## **Objection to Proposed Development**

Budawang School for Specific Purposes

SSD-8845345

17 Croobyar Rd Milton

1 SIGN E HYDROTHERAPY ELEVATION  
1: 100

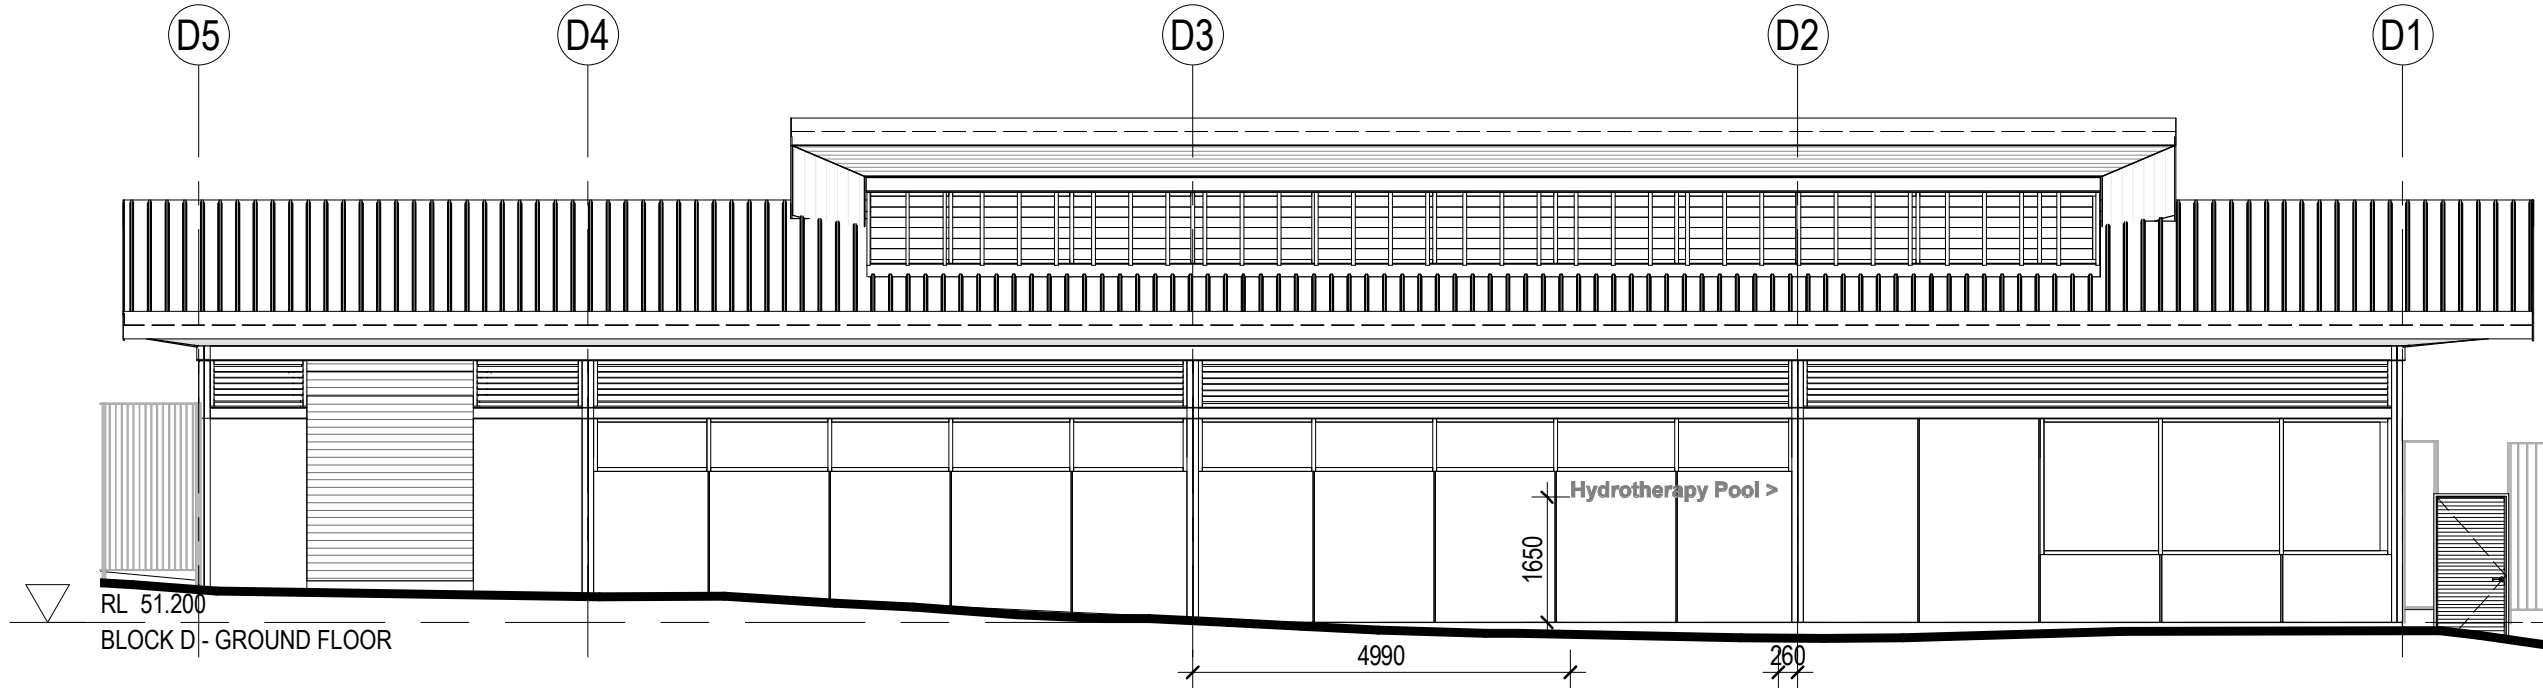
The BSSP documents mention a large lit school sign outside the proposed hydrotherapy pool that will face Croobyar Rd. If this large illuminated sign is to be installed, it must be turned off at night to reduce unacceptable night-time visual and light pollution in Croobyar Rd.

1 NORTH ELEVATION FROM CROOBYAR ROAD  
1:200

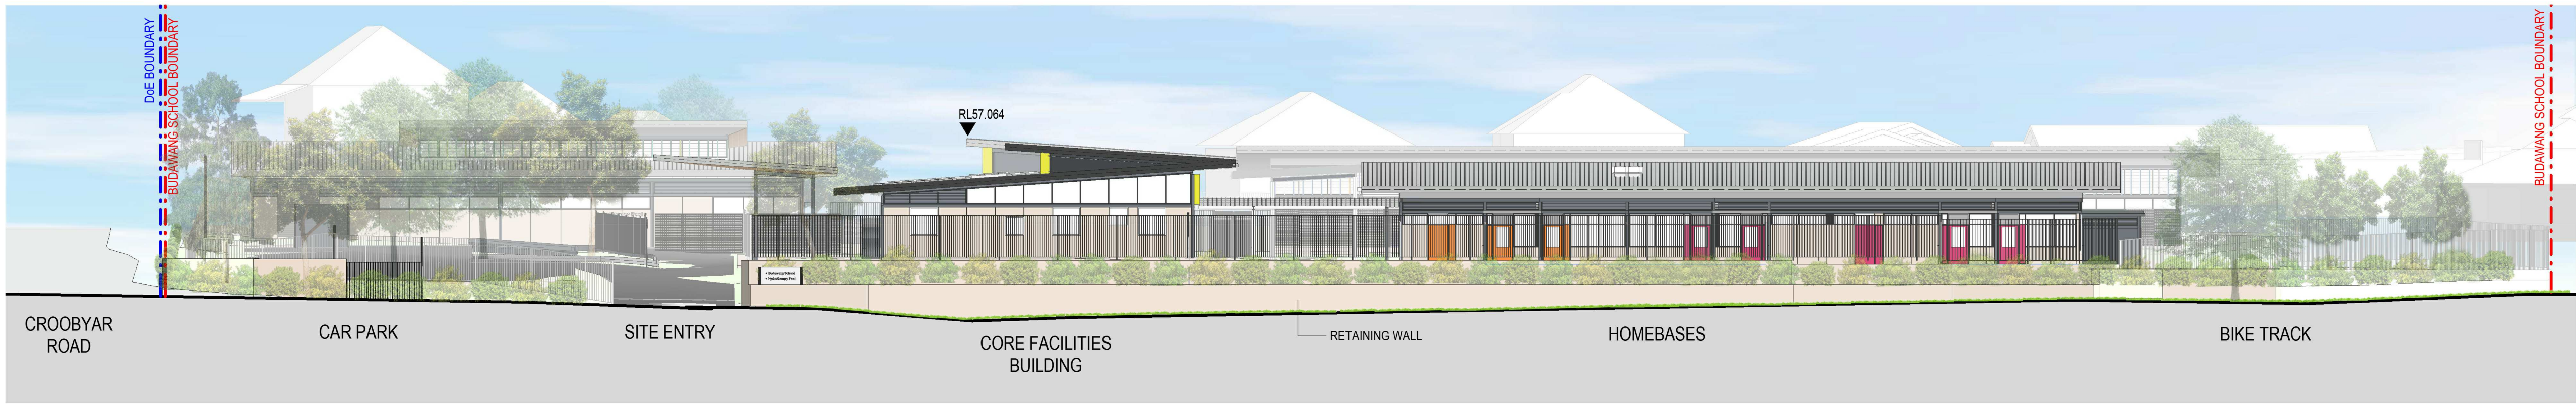
The overdevelopment of this site means that the proposed Hydrotherapy Pool building is sited only 3m from the Croobyar Rd (northern) boundary, with its roofline only 2m from the boundary. All residential development on Croobyar Rd must comply with a minimum 6m setback. Given the bulk and scale of this building presenting to Croobyar Rd, this building setback must be increased to at least 6m.

2 HYDROTHERAPY NORTH ELEVATION.  
1:100

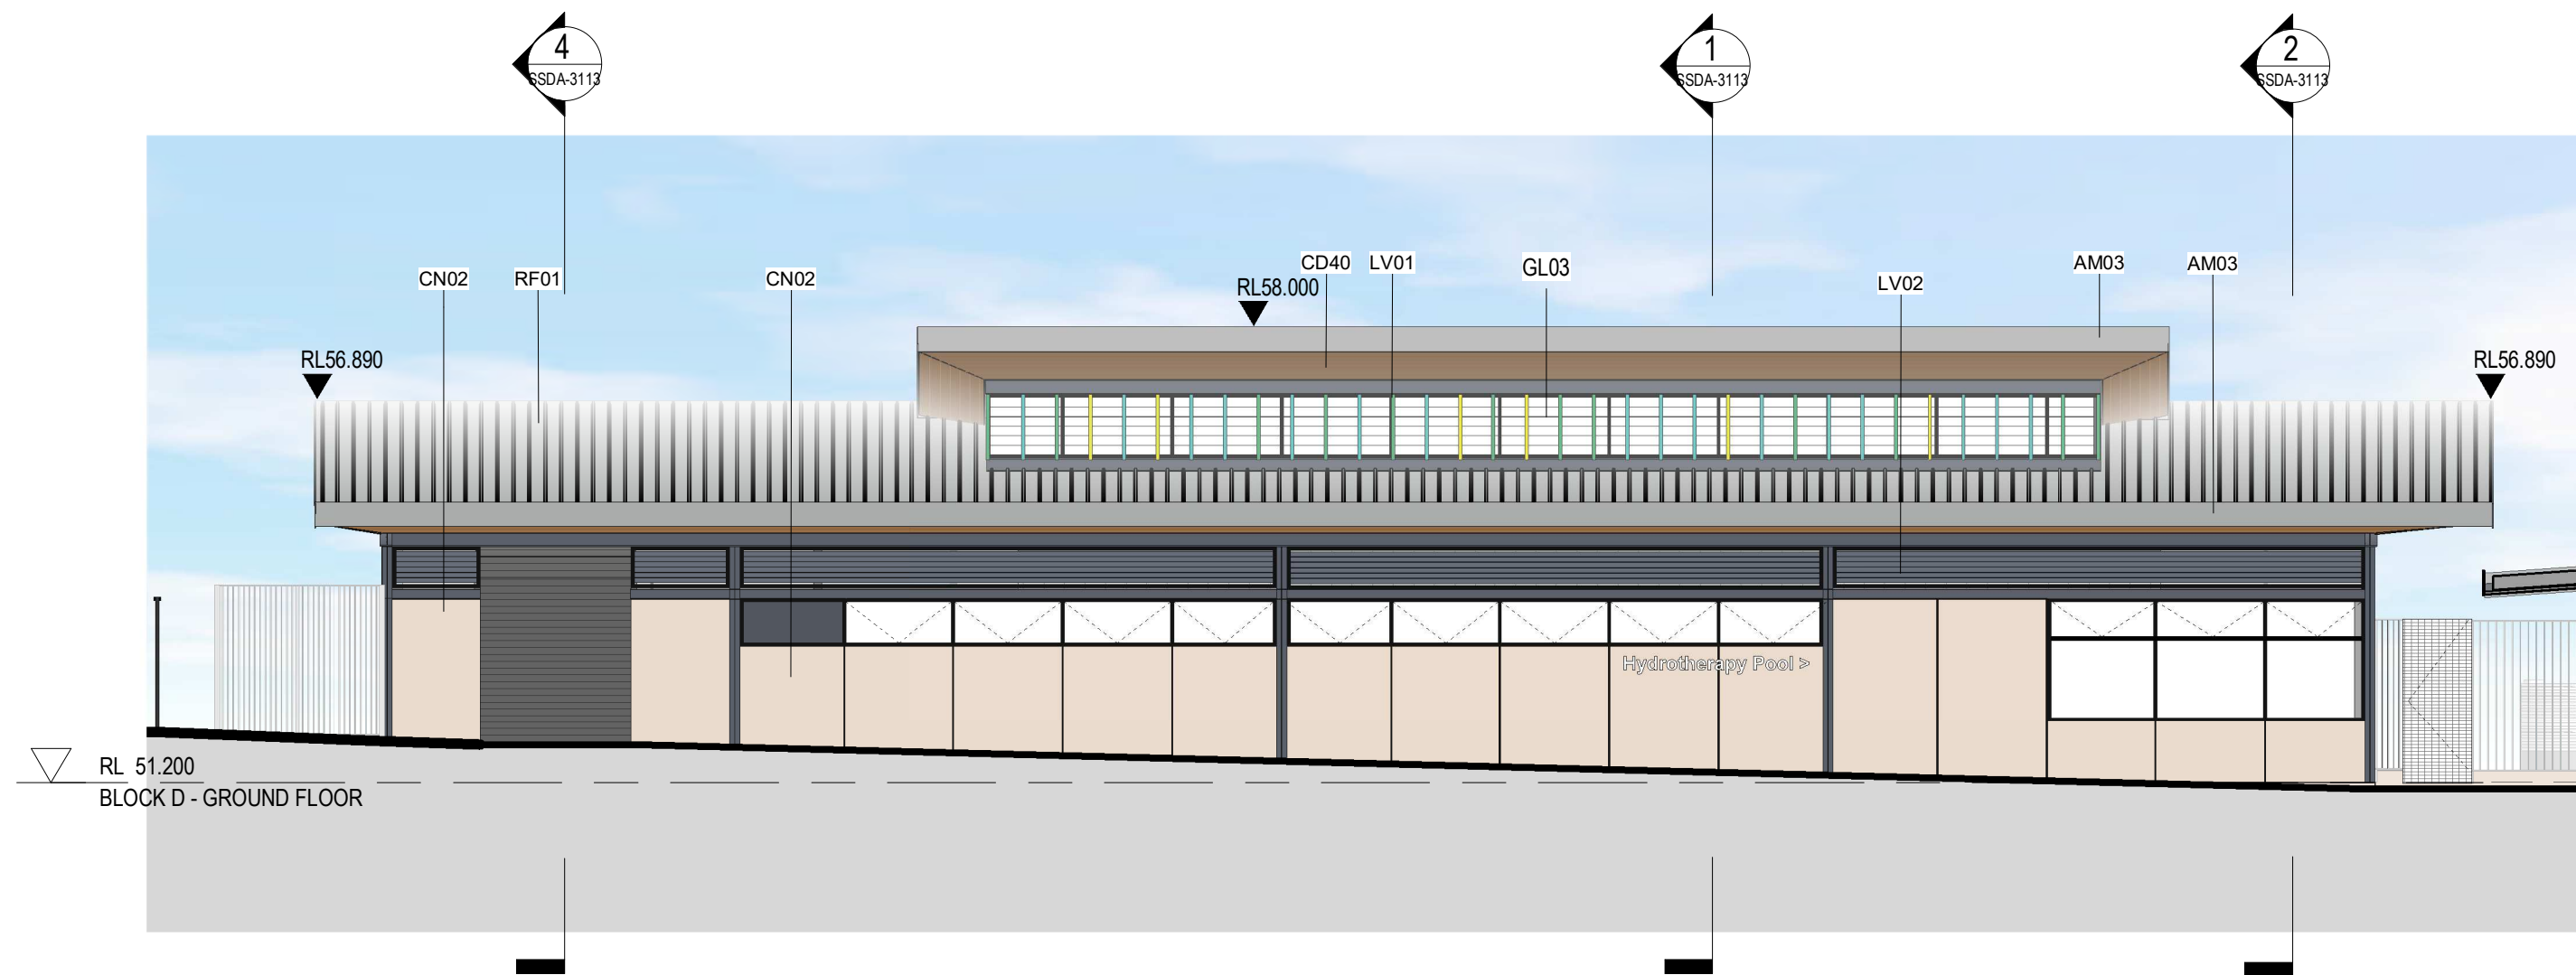
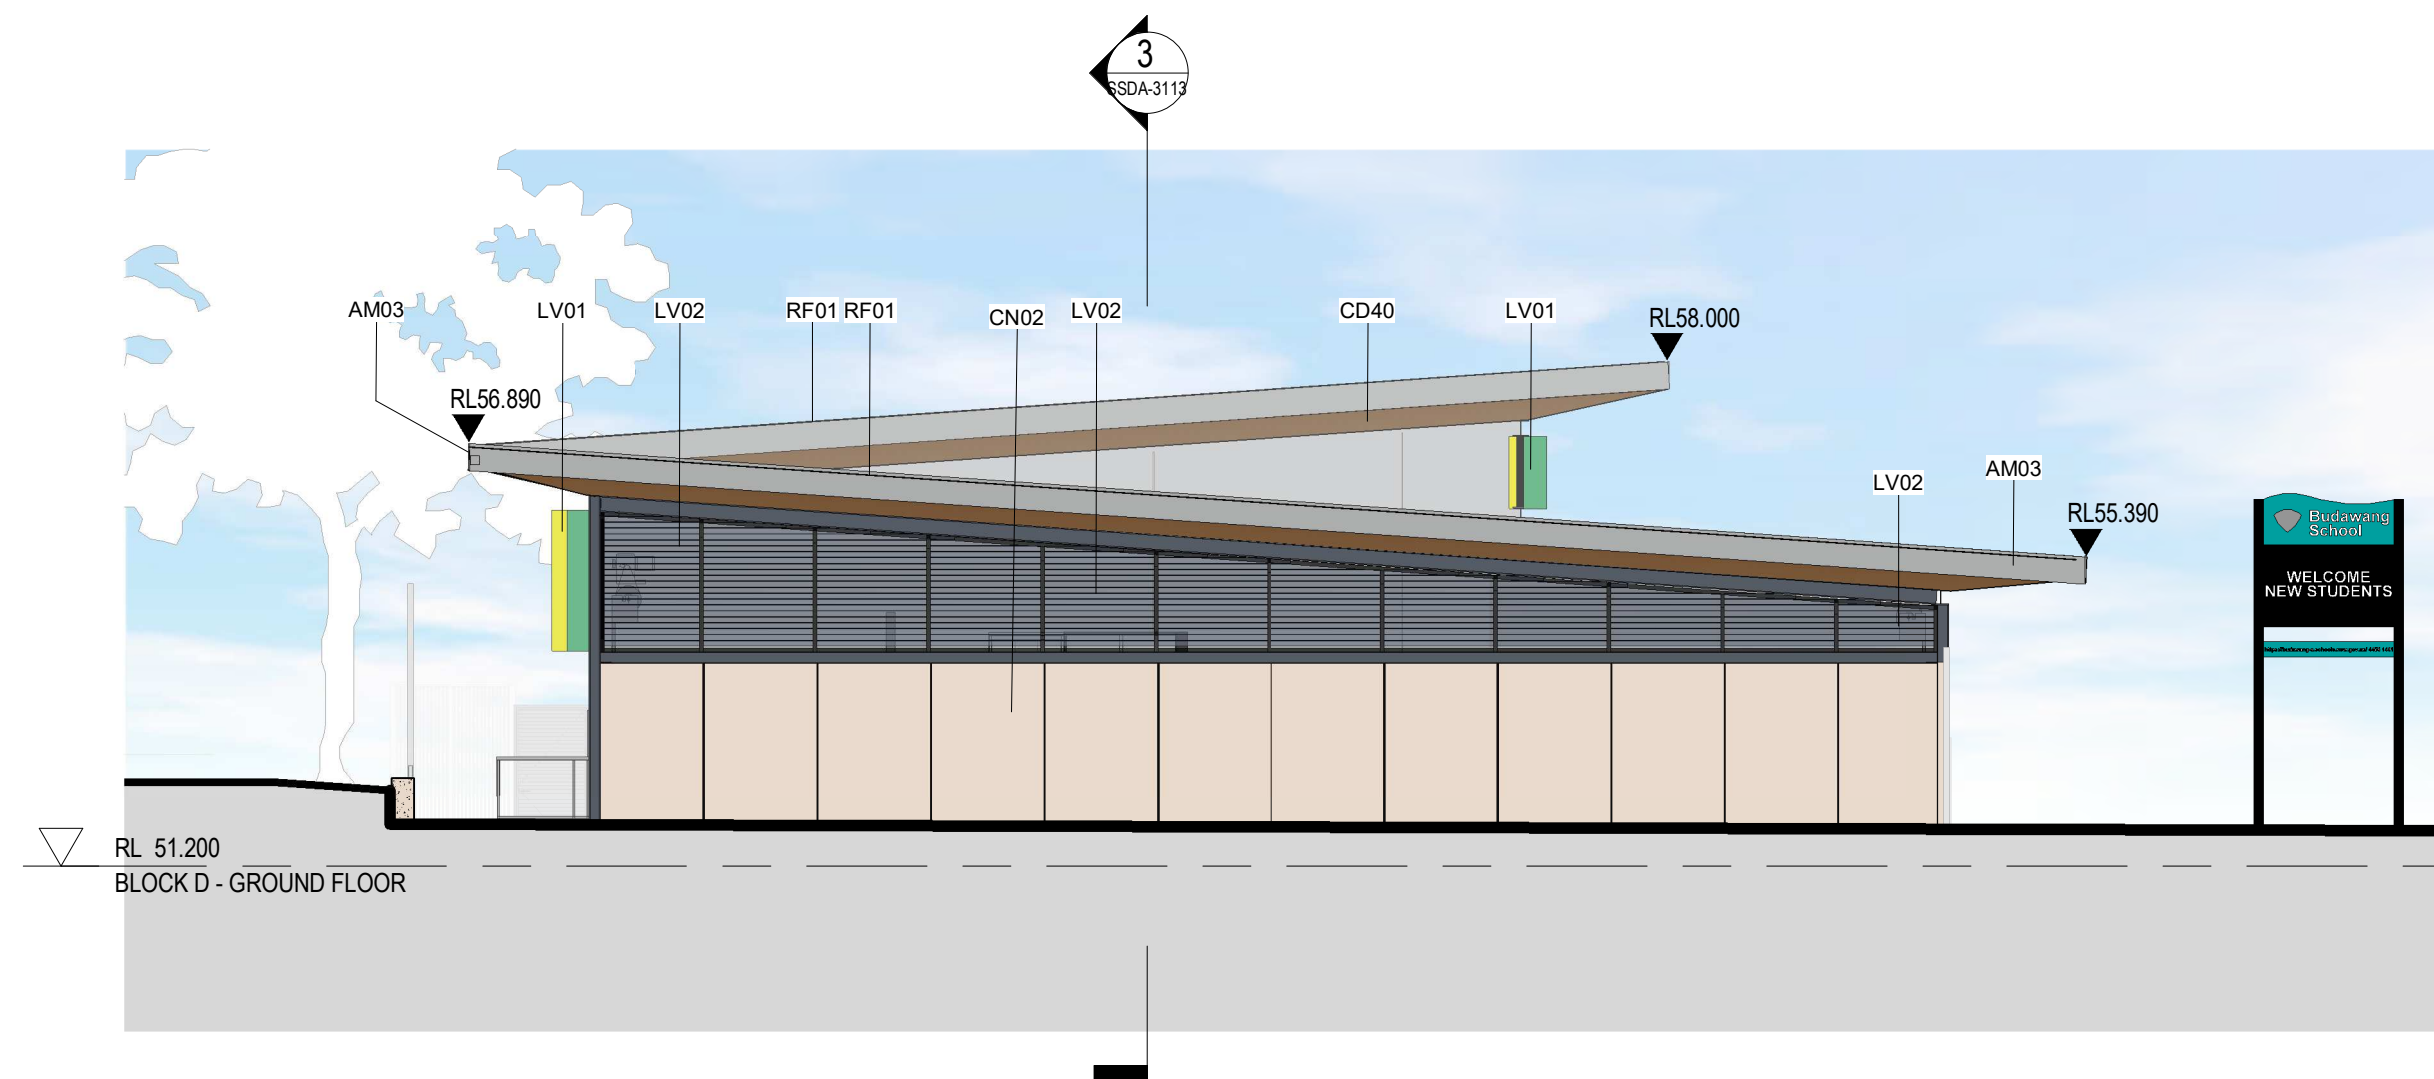
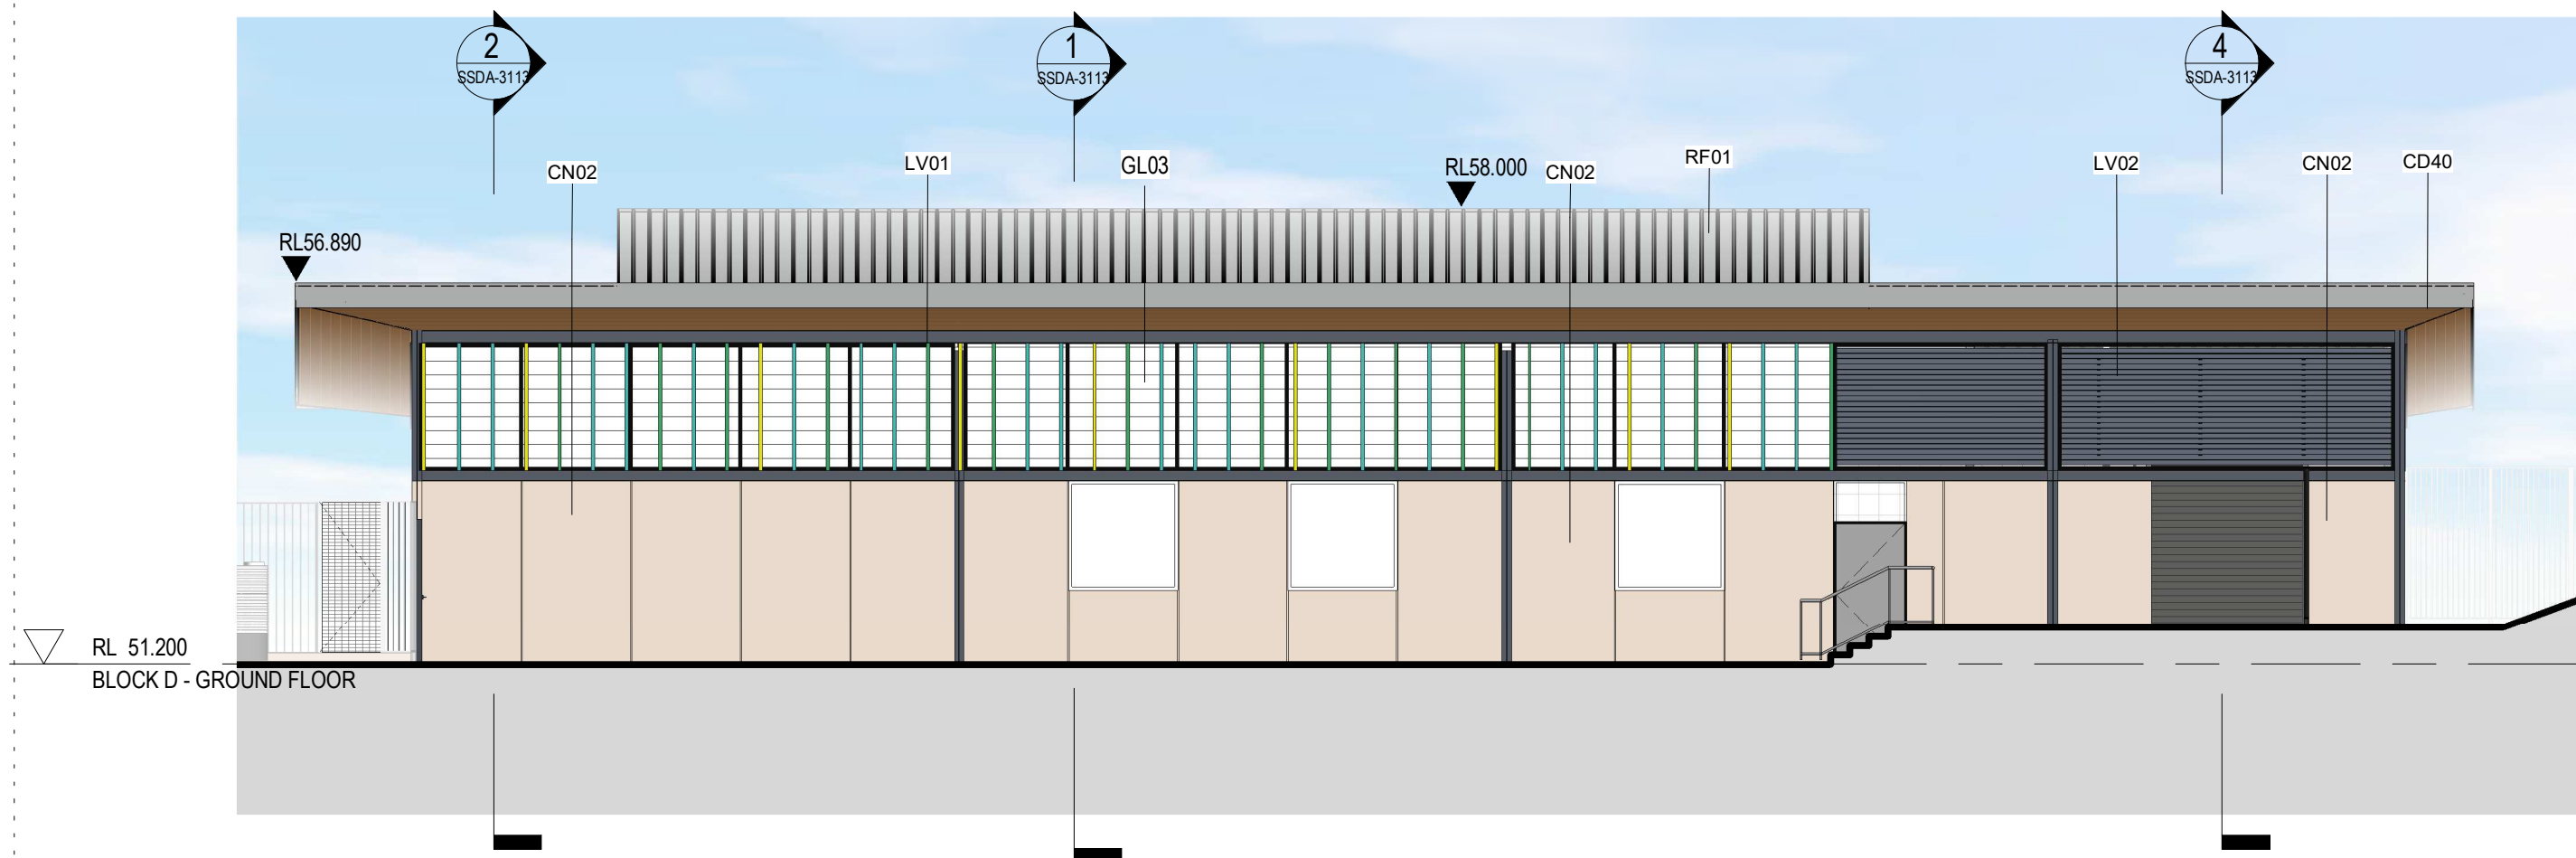
The bulk and siting of the proposed hydrotherapy pool will also have unacceptable visual impact on the nearby 'Heritage Bakery', a 150 year-old stone building that is the oldest continually occupied commercial building in the Shoalhaven. The impact on the Bakery is said to be mitigated by the 'retention' of trees between the pool and the Bakery. But these trees are on the Heritage Bakery's land, not DoE land. This means the proposed plan requires the Heritage Bakery owners to provide their own mitigation of the impact of the bulk and scale of the hydrotherapy pool building, when the BSSP design should include its own planting and screening to do that.
